Urban Design Review Panel Report

500 Coventry Road, Ottawa

December 12, 2025

**RE: Urban Design Review Panel Report
Site Plan Control Application
500 Coventry Road, Ottawa**

DRAWING NO. SPA301
REV. 3

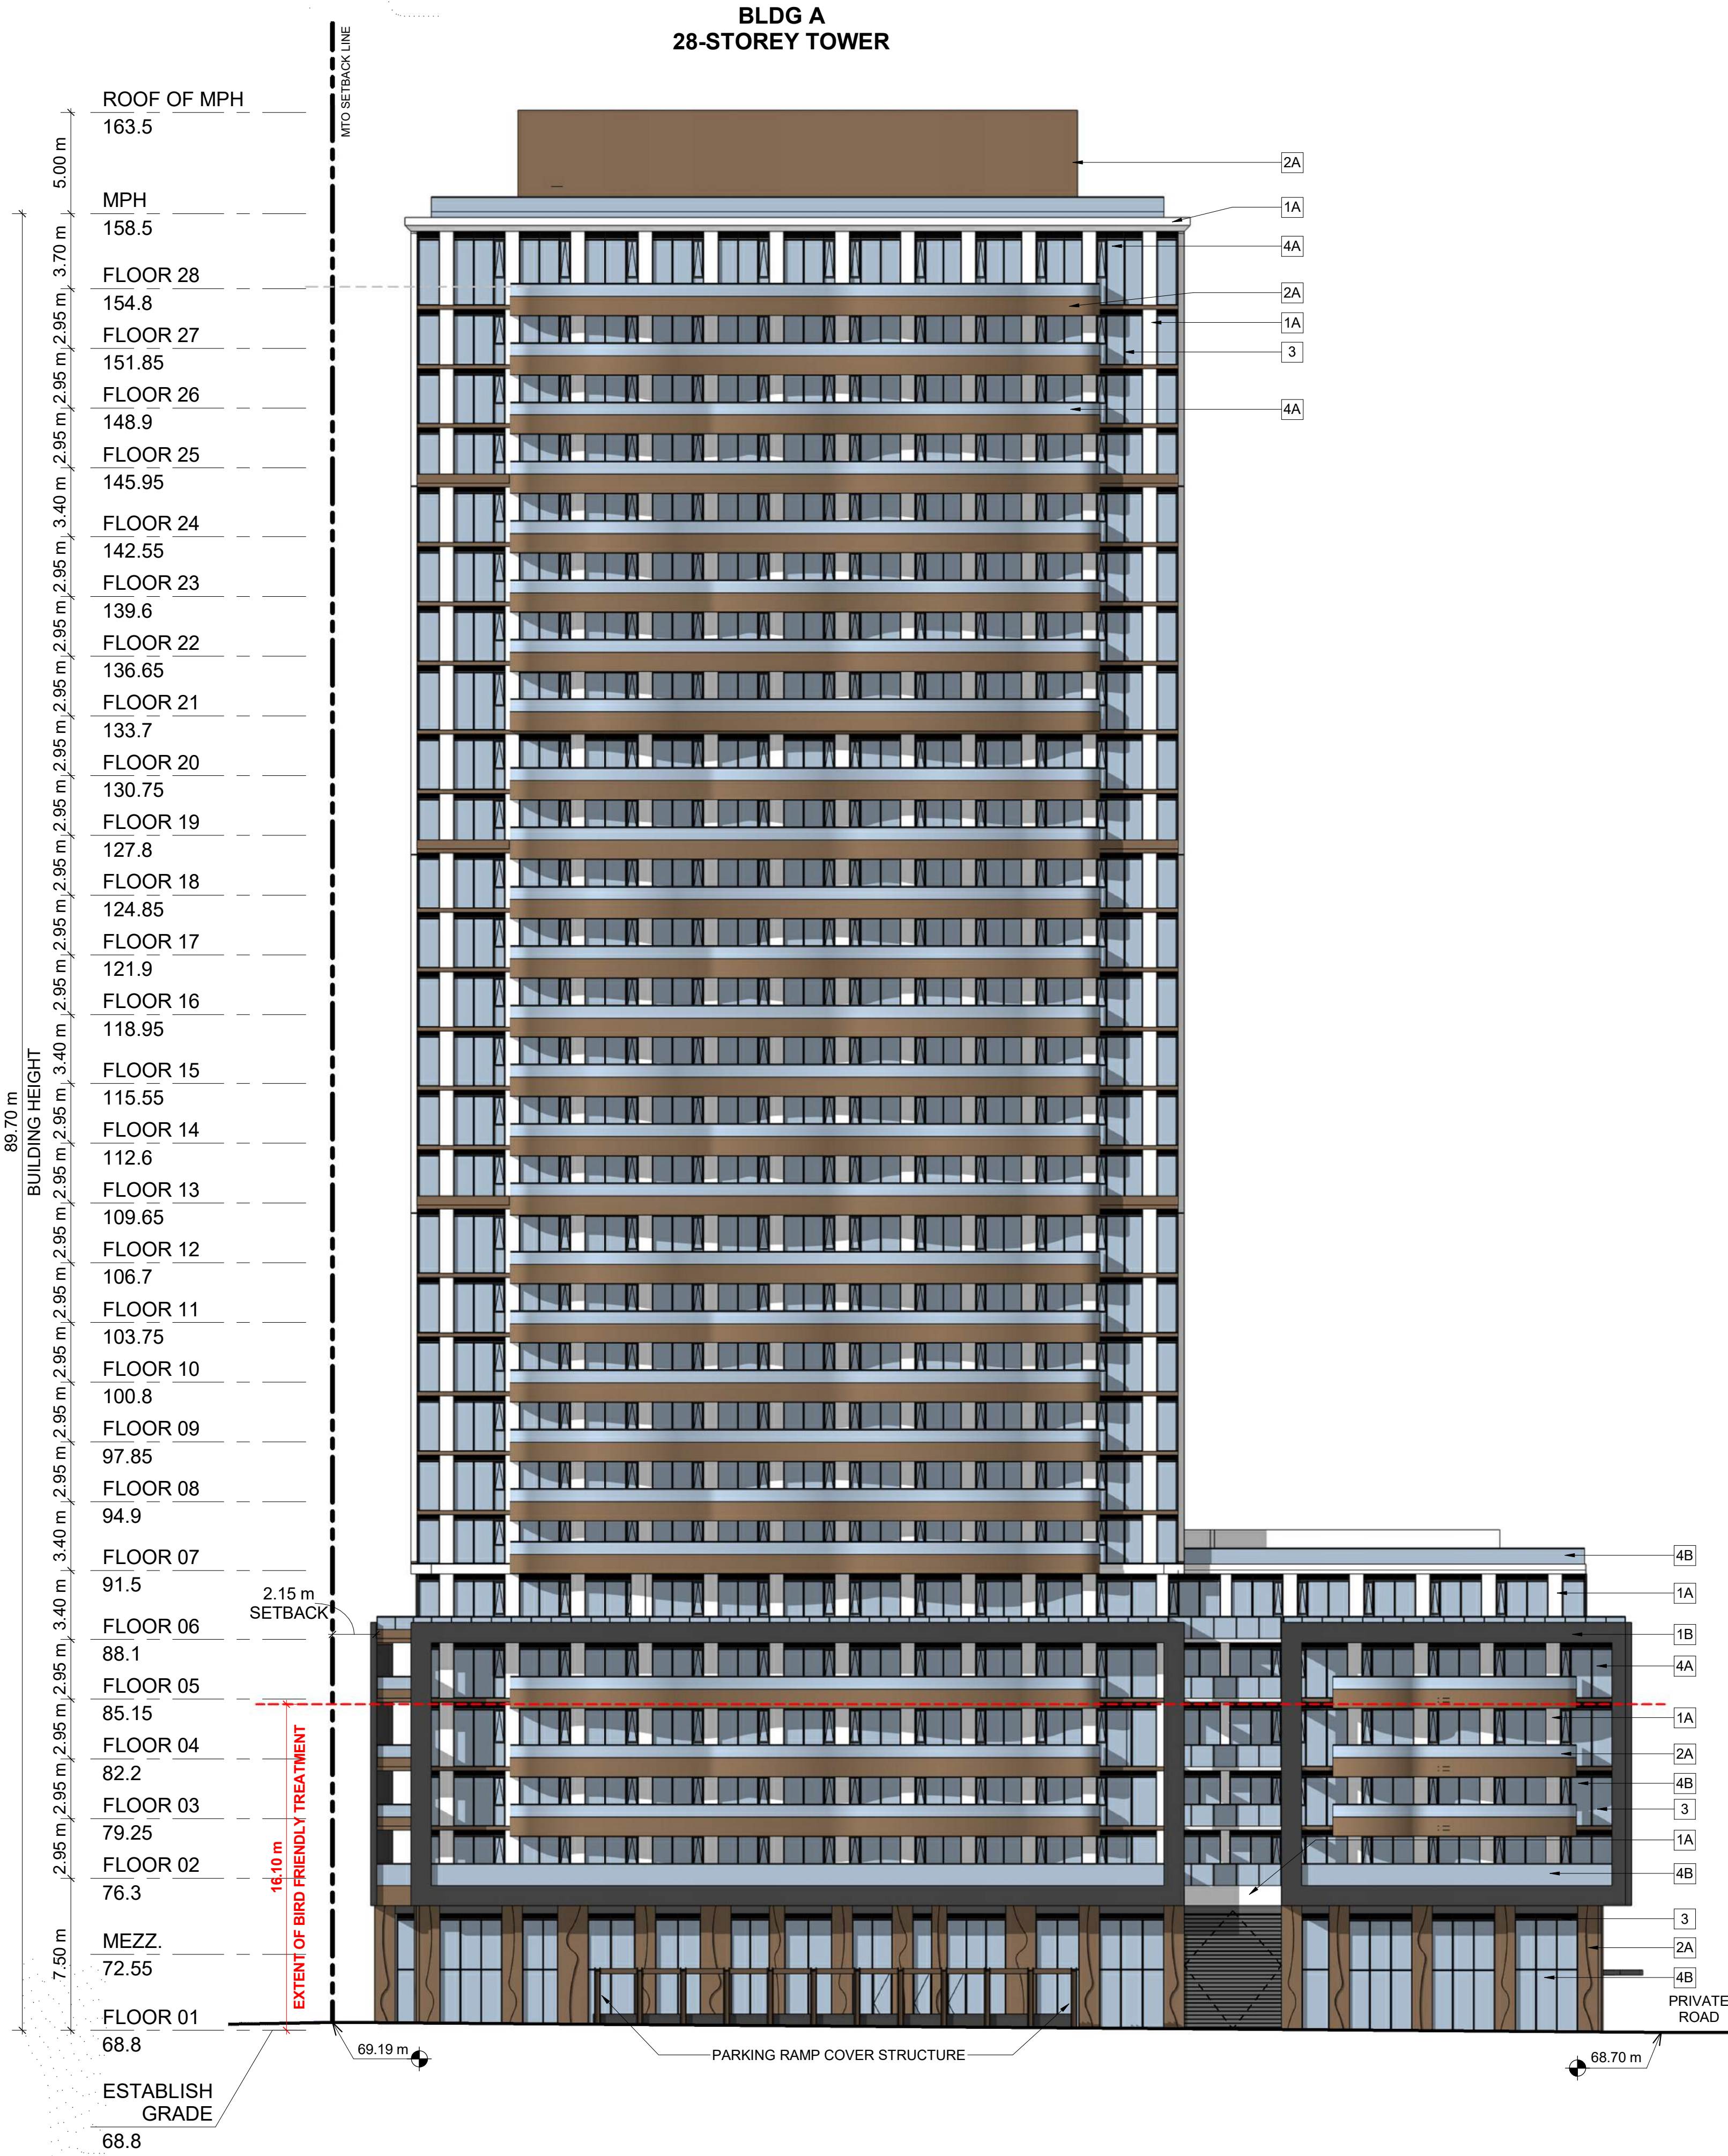
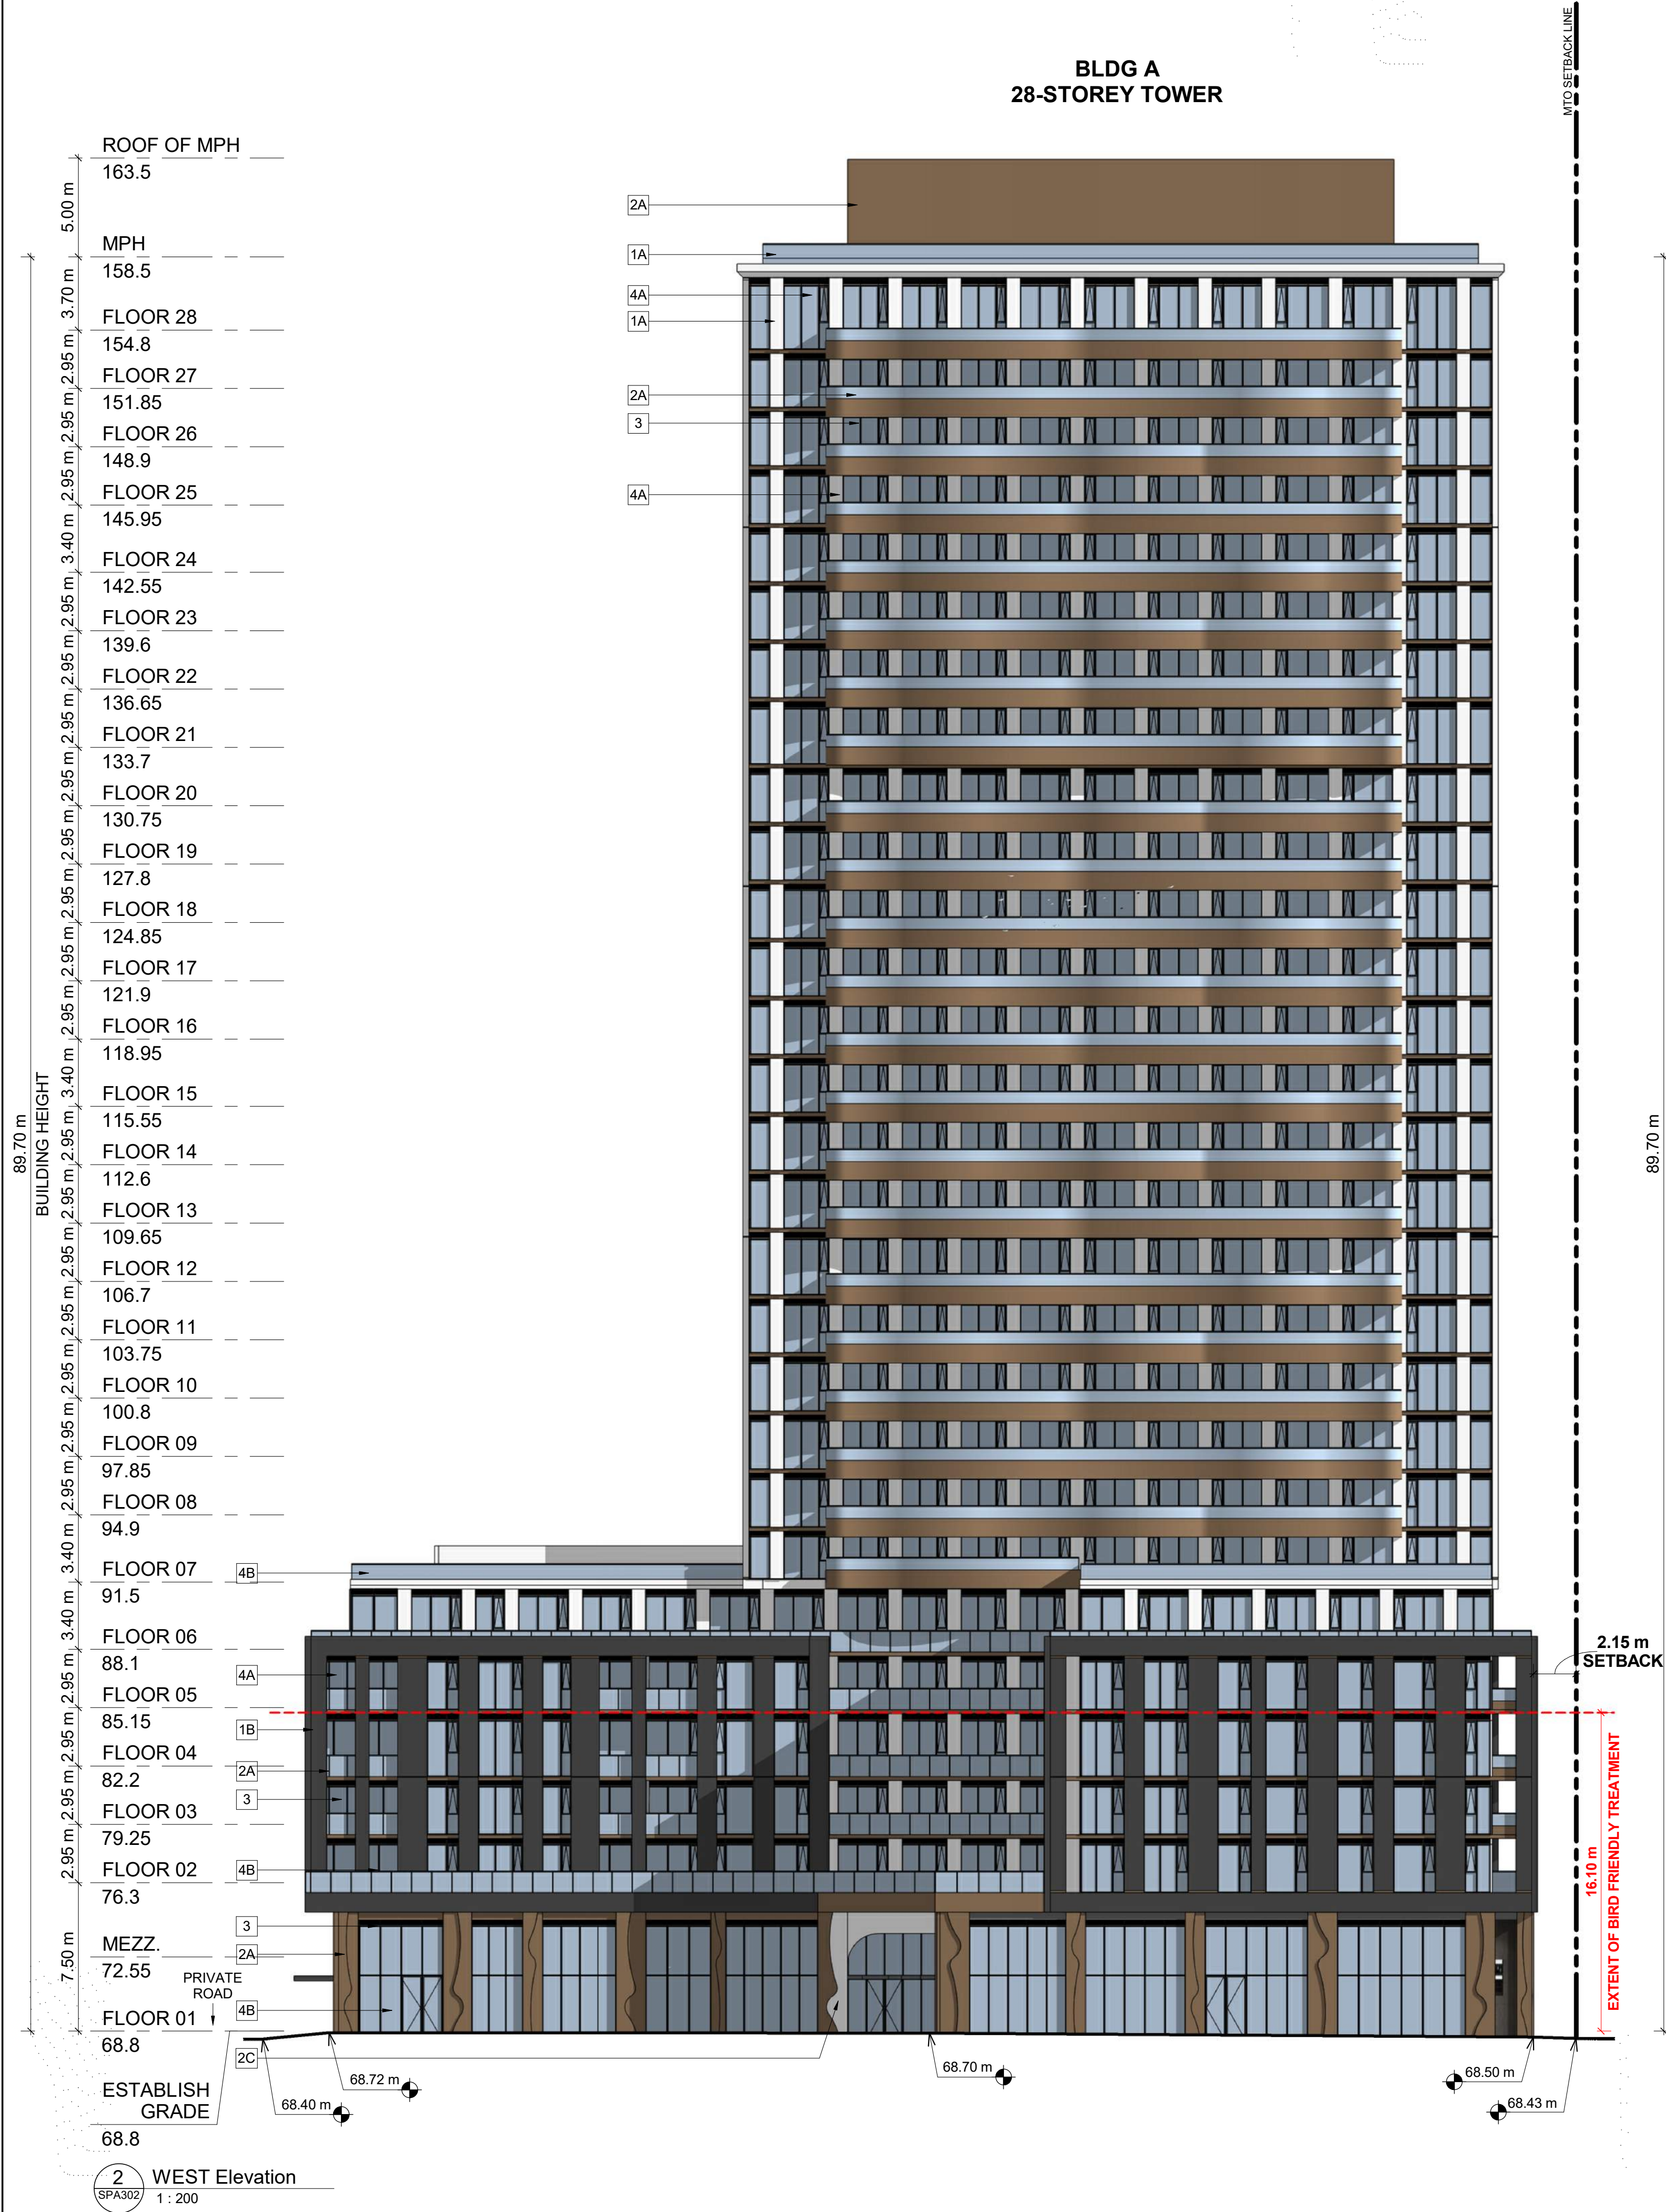
9. The Panel has concerns with the podium (rigid black frames) and tower (undulating glass balconies) contrasts being too sharp.
 - Consider foregoing the heavy black frames in the podium.
 - Consider calming down the contrasting elements between undulating balconies and waterfall façade.

10. The Panel recommends furthering the undulating balconies and water motif to the north and south elevations to create a play between the orthogonal and undulations.

11. The Panel recommends expressing the architecture of the tower 'in the round', integrating the waterfall features with the solidity of the side elements, and softening the contrast between the two.

31. The Panel appreciates the water motif of the tower's architectural expression. The undulations are particularly appreciated with great potential for capturing and playing with light.
 - The Panel recommends leaning more into the undulating balcony articulation to further advance the waterfall motif.
 - The Panel recommends wrapping the undulating balconies around onto the north and south elevations of the tower, at least partially if not fully.

32. The Panel has some suggestions to reduce the contrast between the vertical pre-cast white strips on the elevations, and the undulating balconies of the east and west elevations.

- The Panel recommends as one approach, adding a softness to the vertical white pre-cast element, and further exploring how this waterfall motif could also be integrated to soften the vertical strips.

33. The Panel recommends pulling back on the ground level vertical undulations, and the heaviness of the black framework on the podium.

Response: Understand that building A is the first of the master plan, we want it to be a gateway building that will stand out and become a landmark of the area. The balconies and the waterfall façade are the feature of our design intent.

Response: We appreciate the suggestion. The undulation of the balconies is intended to achieve a certain effect on the east and west elevations mainly and are purposefully not being proposed on North and South elevations to achieve a contrast and maximize the effect where they are being proposed.

Response: We appreciate the suggestion. The undulation of the balconies is intended to achieve a certain effect on the east and west elevations mainly and are purposefully not being proposed on North and South elevations to achieve a contrast and maximize the effect where they are being proposed.

Response: We appreciate the suggestion. The undulation of the balconies is intended to achieve a certain effect on the east and west elevations mainly and are purposefully not being proposed on North and South elevations to

achieve a contrast and maximize the effect where they are being proposed. We purposefully located balconies where needed and prefer limiting the amount of slab projections where not necessary.

Response: We appreciate the suggestion. As we continue to refine the design we will consider if a stone-like material can be used to anchor the waterfall motif as suggested.

Response: We appreciate the suggestion. As we continue to refine the design, we will consider pulling back on the ground floor vertical undulations and we will also re-look at how we can avoid the heaviness of the black framework of the podium.
